Case Officer: Nathanael Stock**Recommendation:** Refuse**Applicant:** Mr K Bishop**Proposal:** Change of Use and conversion of 1no agricultural building into 1no self-contained dwellinghouse (Use Class C3) including associated operational development under Part 3 Class Q (a) and (b)**Expiry Date:** 20 March 2020

- 2.3. Documents submitted in support of this application: "LOCATION PLAN – not to scale" and dated Dec 2019, drawing "07" (existing floor plans and elevations), drawing "05" (Block plan @1:500), drawing "03" (Proposed floor plan), drawing "04" (Proposed elevations) and a Structural Appraisal by Wellan Ltd, dated December 2019.

## **Sketch SK/01 Structural Plans and Details**

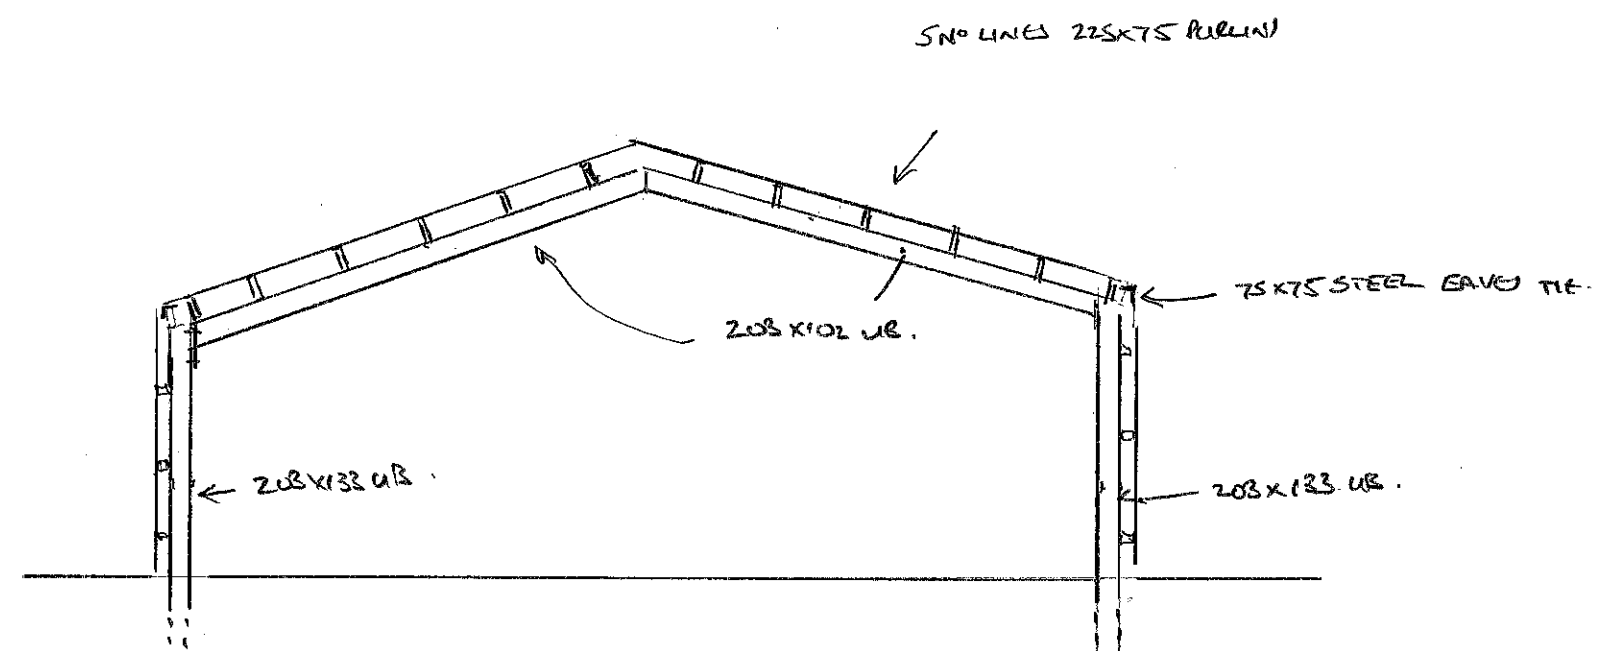
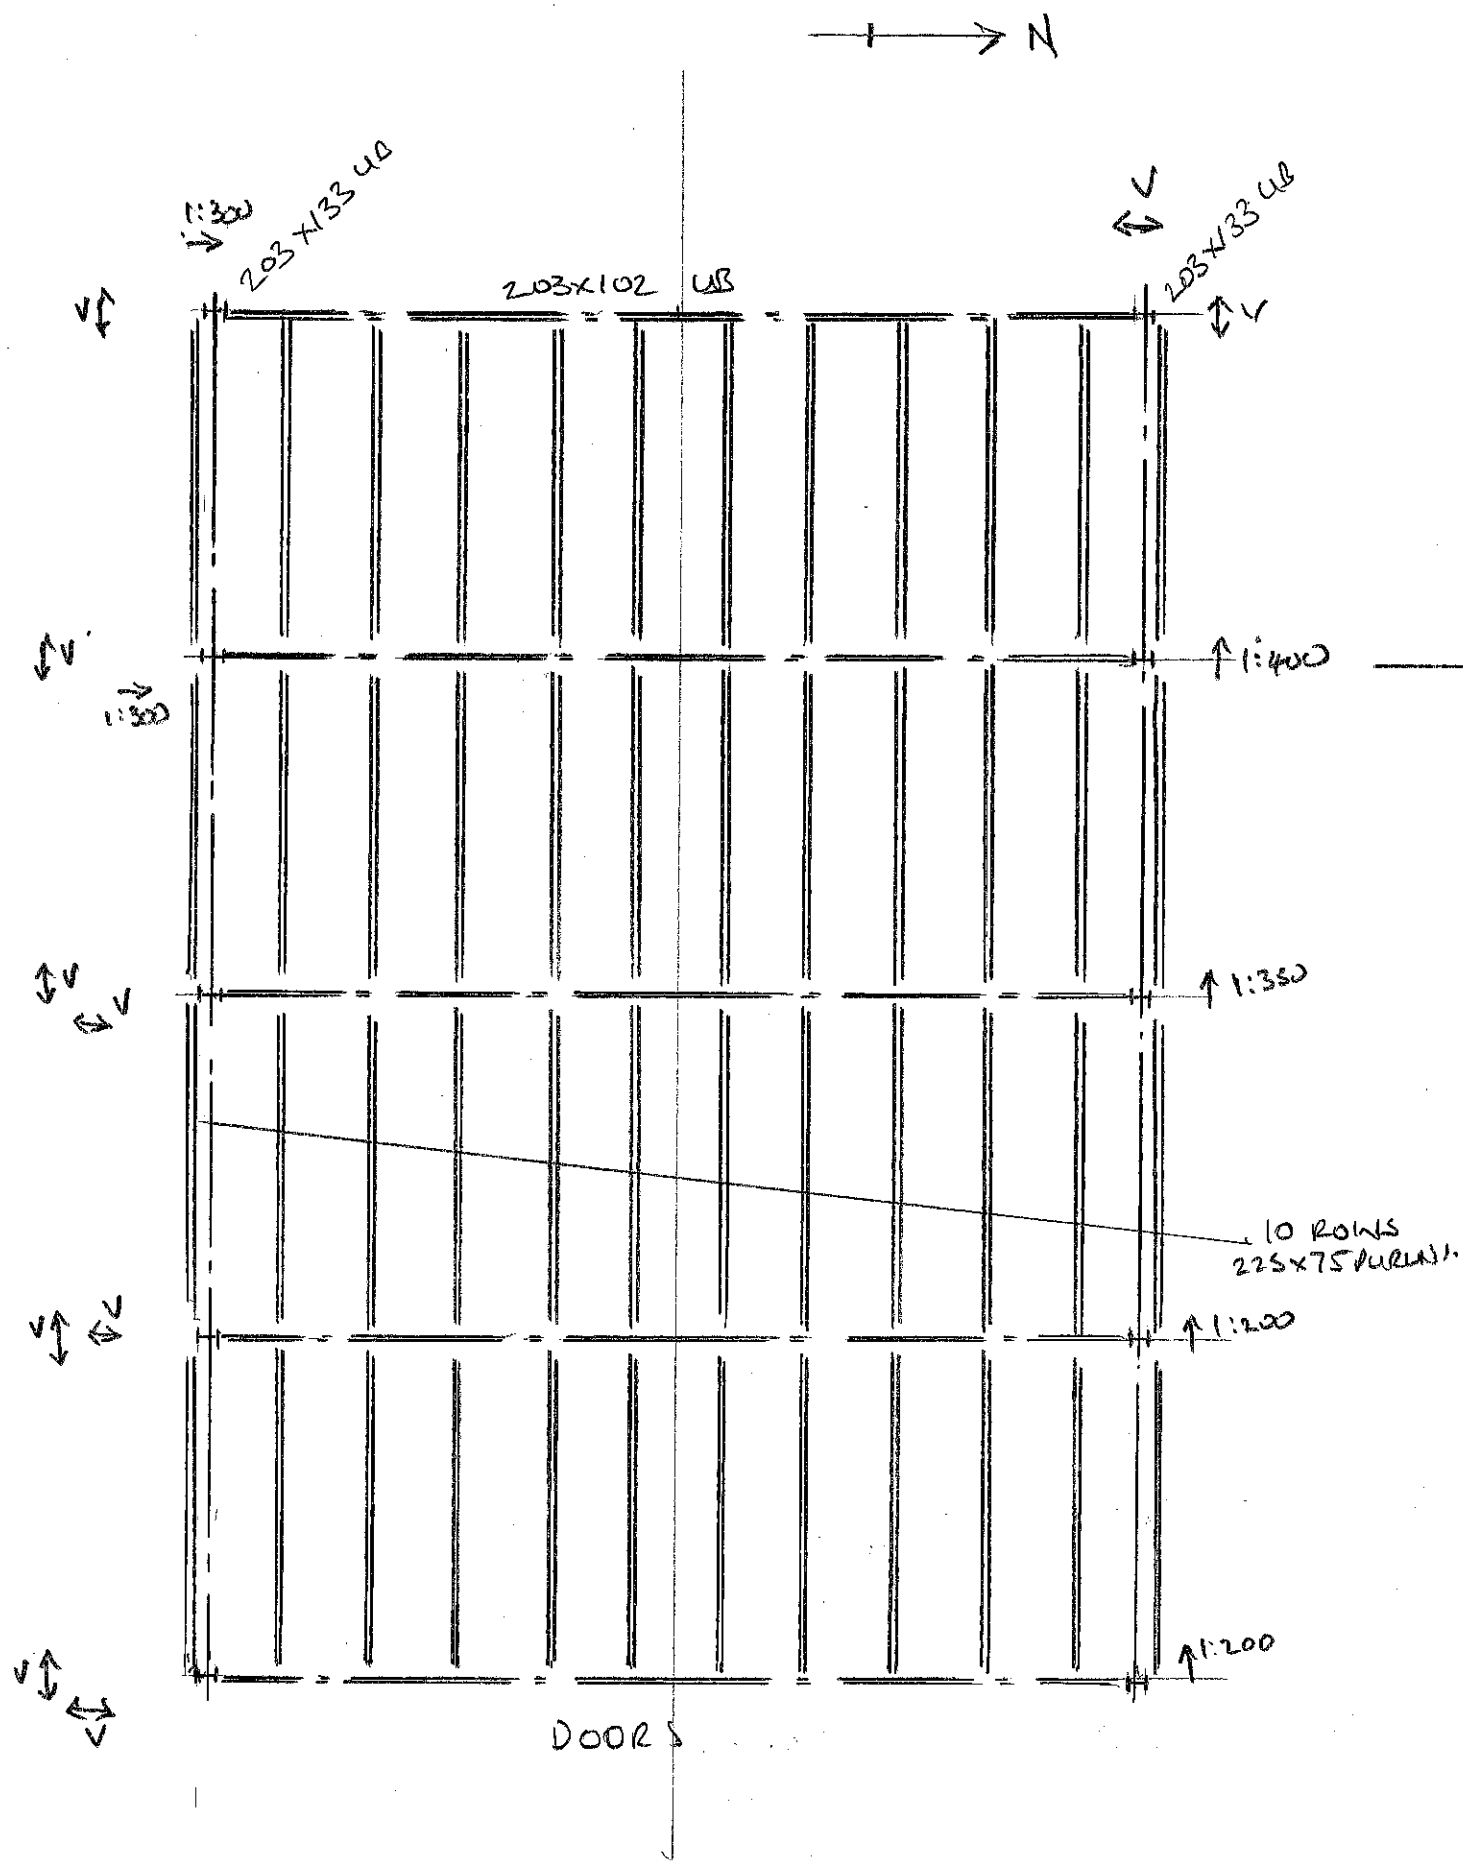
- 8.10. Officers have reviewed the Structural Assessment by Wellan submitted with the application. The report states that there would be "no alteration to the existing steel portal frame or the roof structure" – although the submitted plans would not bear this out, and at the time of the officer's site visit it seemed clear that the roof would need to be replaced.

- 8.11. It is noted that the Structural Assessment did not include any review of the foundations to the barn; it mentions that the barn is clad on all four faces, whereas one side is open, and the building dates to between 30-50 years whereas it was approved in 1999/2000.

- 8.12. Based on the observations of the Structural Assessment, review of the plans submitted with the application and observations made at the officer's site visit, it is considered that the existing structure is not capable of being converted. The proposals show a structure to be built within the existing structure, and in reality this is what would be required for there to be a dwelling here.
